# KITTITAS COUNTY

### MEMORANDUM

SUBJECT: Brownlee Short Plat SP-16-00004

BROWNLEE SHORT PLAT
PART OF SECTION 36, T. 17 N., R. 19 E., W.M.
KITTITAS COUNTY, WASHINGTON

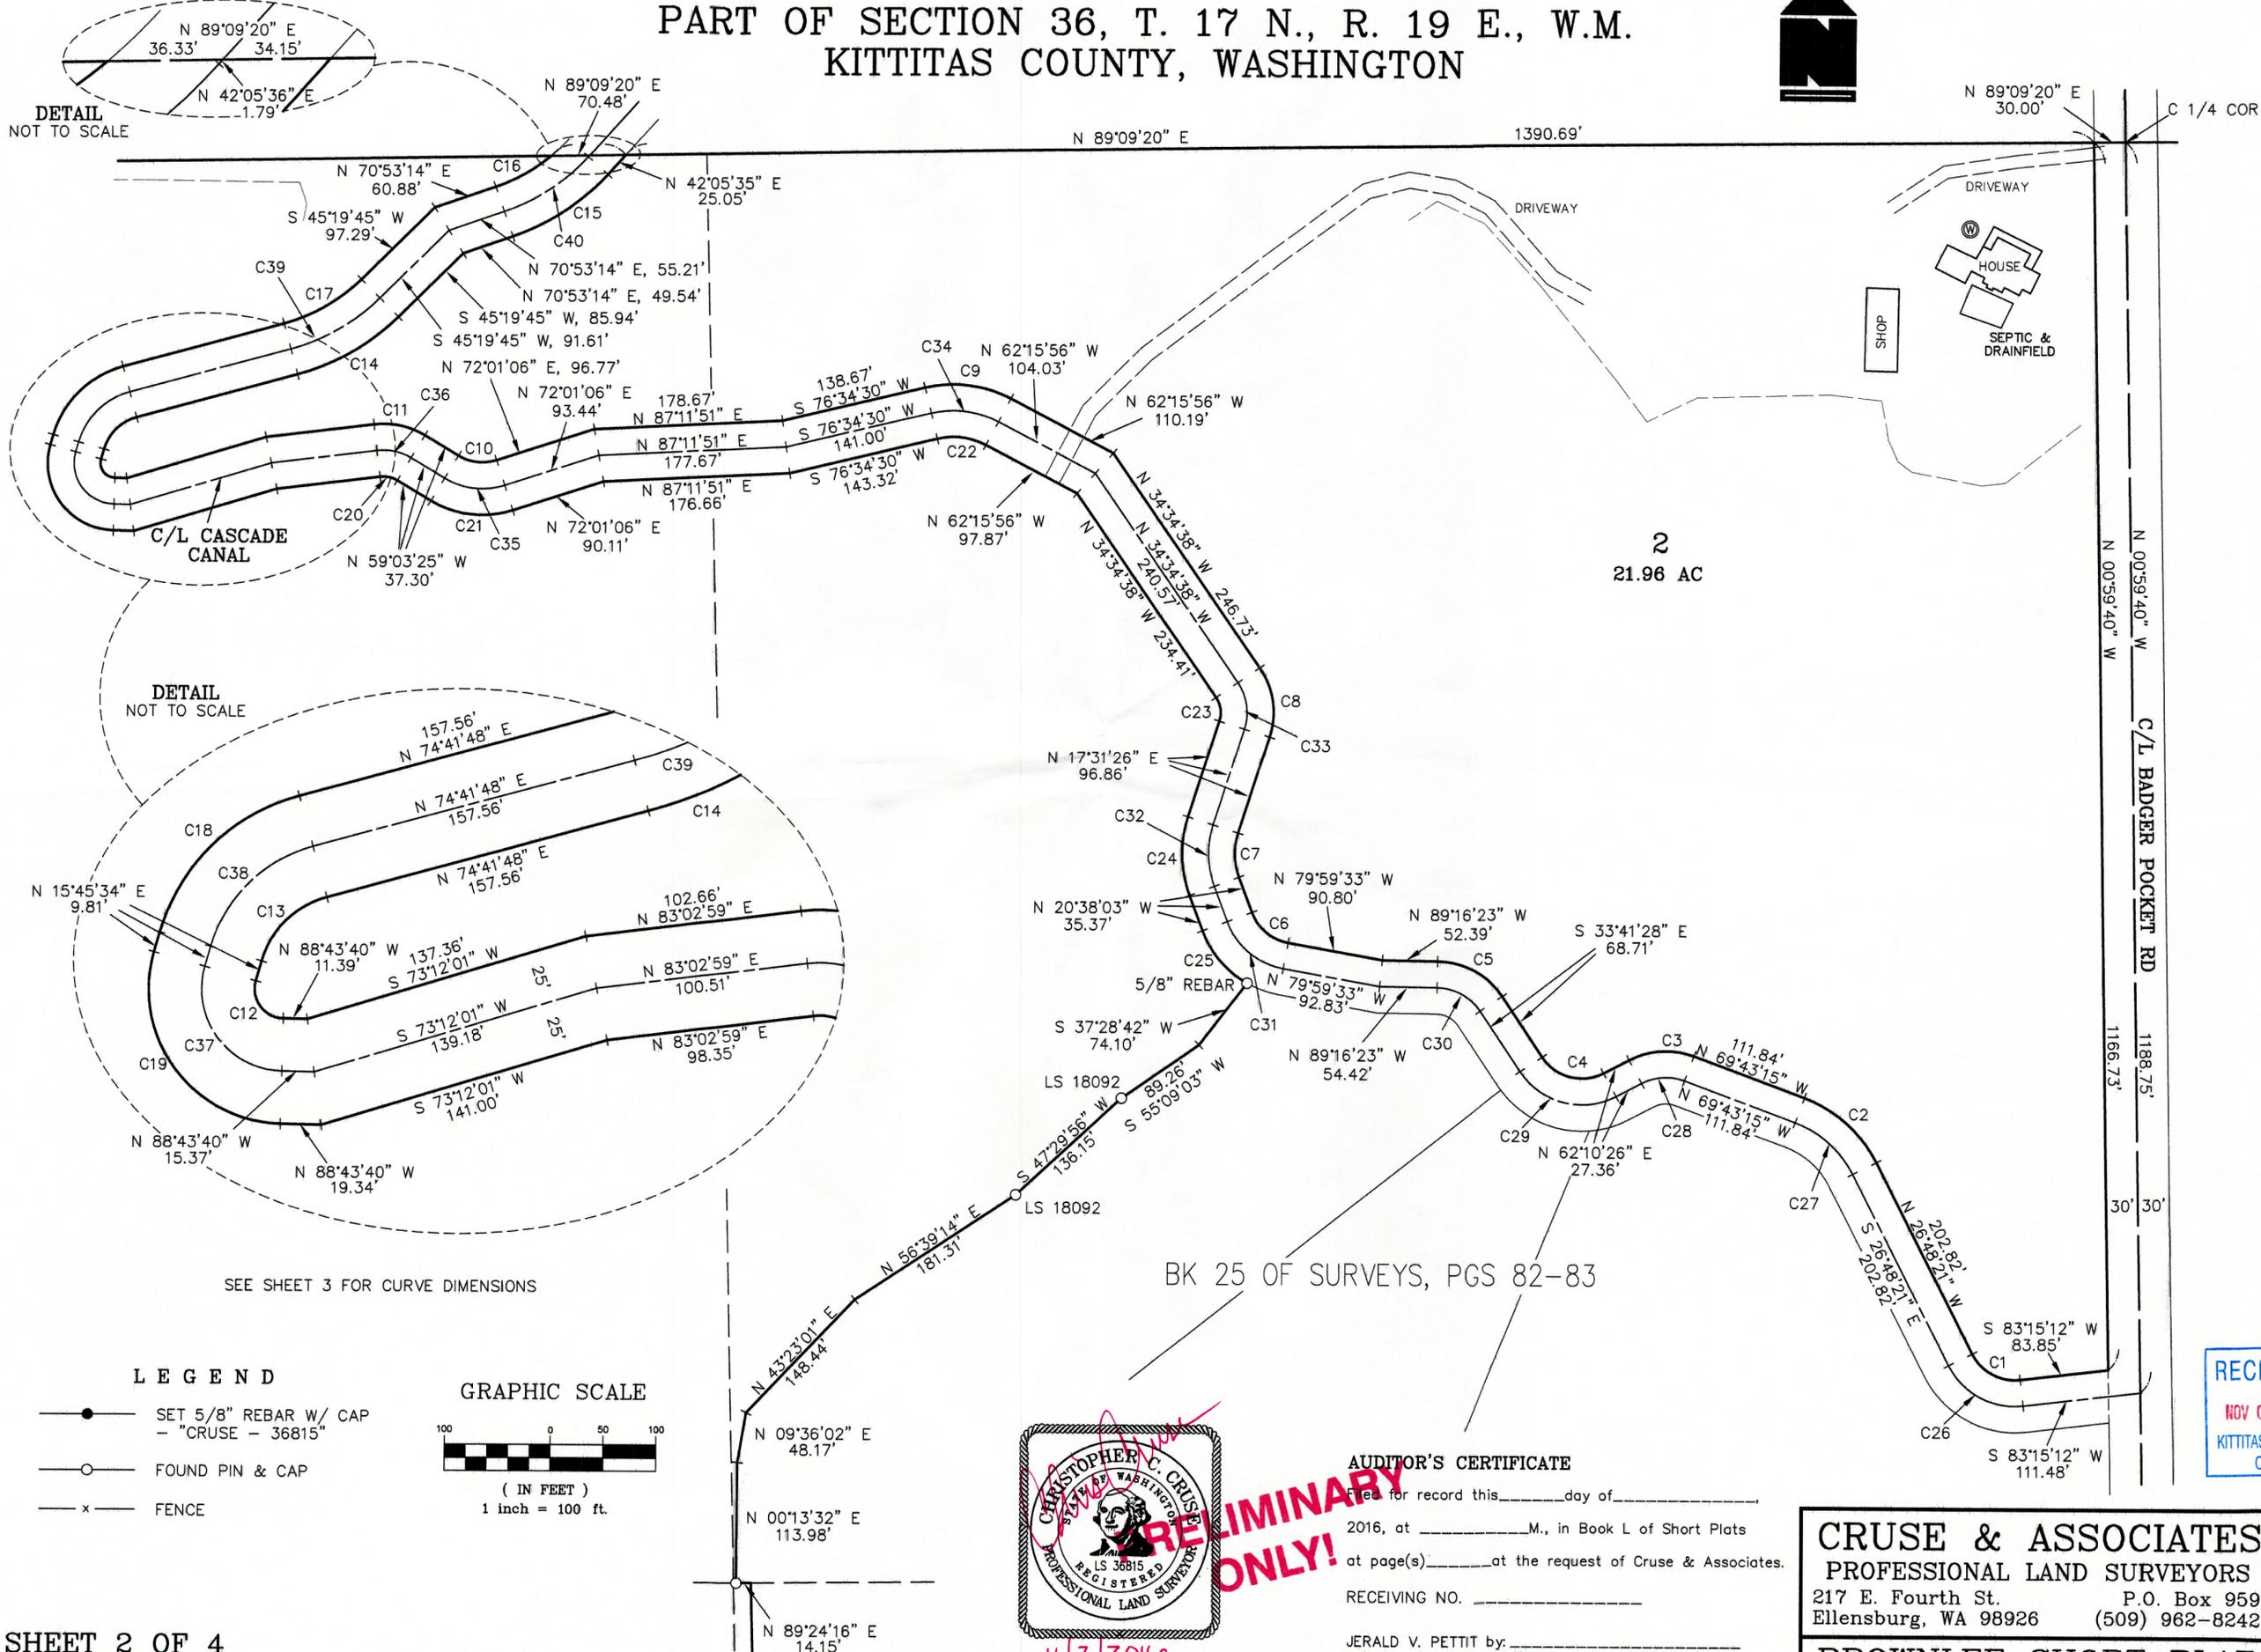
1. Transportation Concurrency: Is required on all divisions of land prior to final approval.
2. Access to Lot 1: The existing 60' Easement Q located off of 4<sup>th</sup> Parallel Road is for agricultural use only. An access driveway for the property will need to be established either by amending the existing agricultural easement to allow for all uses, or through a joint use driveway easement across lot 2. The access easement must be shown on the face of the short plat.
